HPC Project – Non-Material Change 4

Hinkley Point C (Nuclear Generation Station) Order 2013, made 18th March 2013:

**Application for a Non-Material Change in relation to the Hinkley Point C
Permanent Development Site.**

**Response by the Local Planning Authority at Somerset West and Taunton
Council.**

Drawing file: EN010001 / EN010001-006701-HPC-NNBPCP-U0-000-DRW-000001 - Plot Plan Rev04 draft v7.pdf

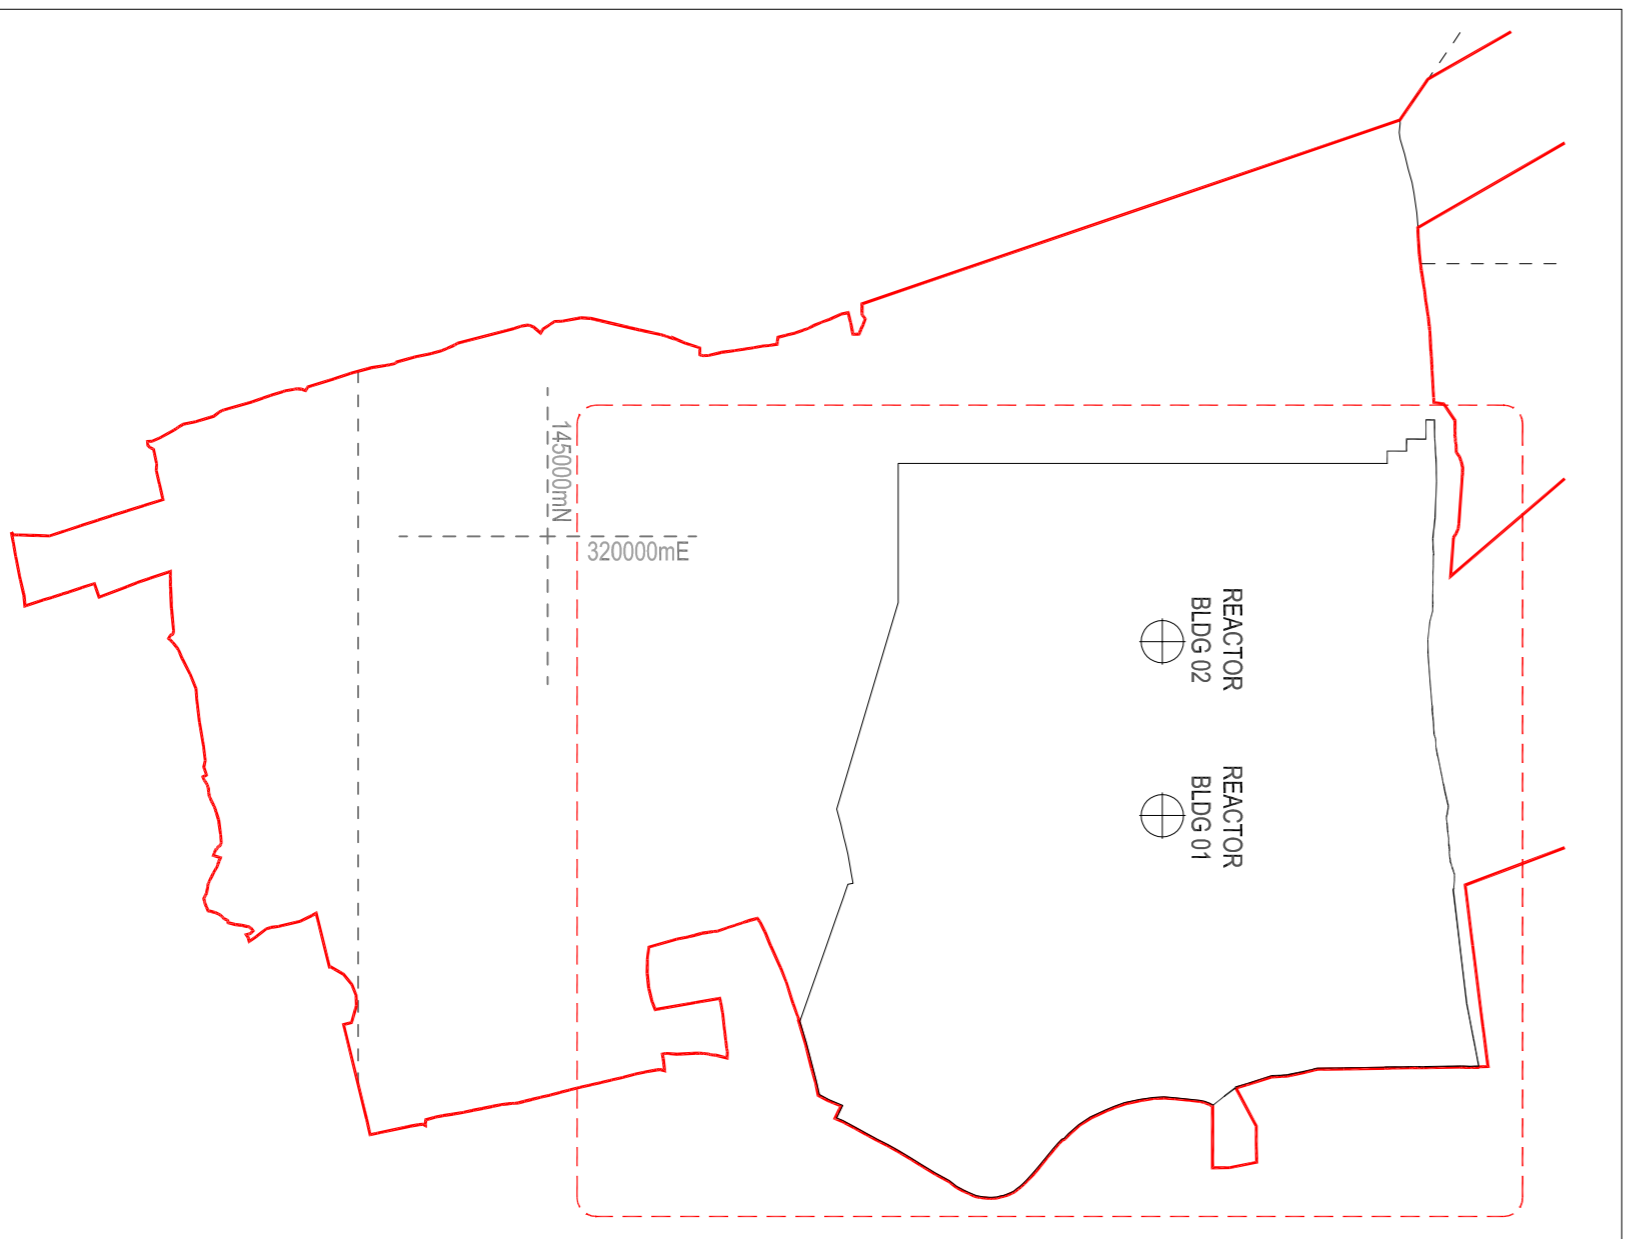
2.6 I do note however, that the Emergency Response Store does not appear on the proposed Site layout Plan (Operational), reference HINK-A1-SL-00-GA-010 which appears at both Appendix 1 to the Application Statement and as a plan in its own right as part of the suite of plans referenced under 'Proposed Plans and Elevations' on the Applicant's website. This should be rectified before any approval is given.
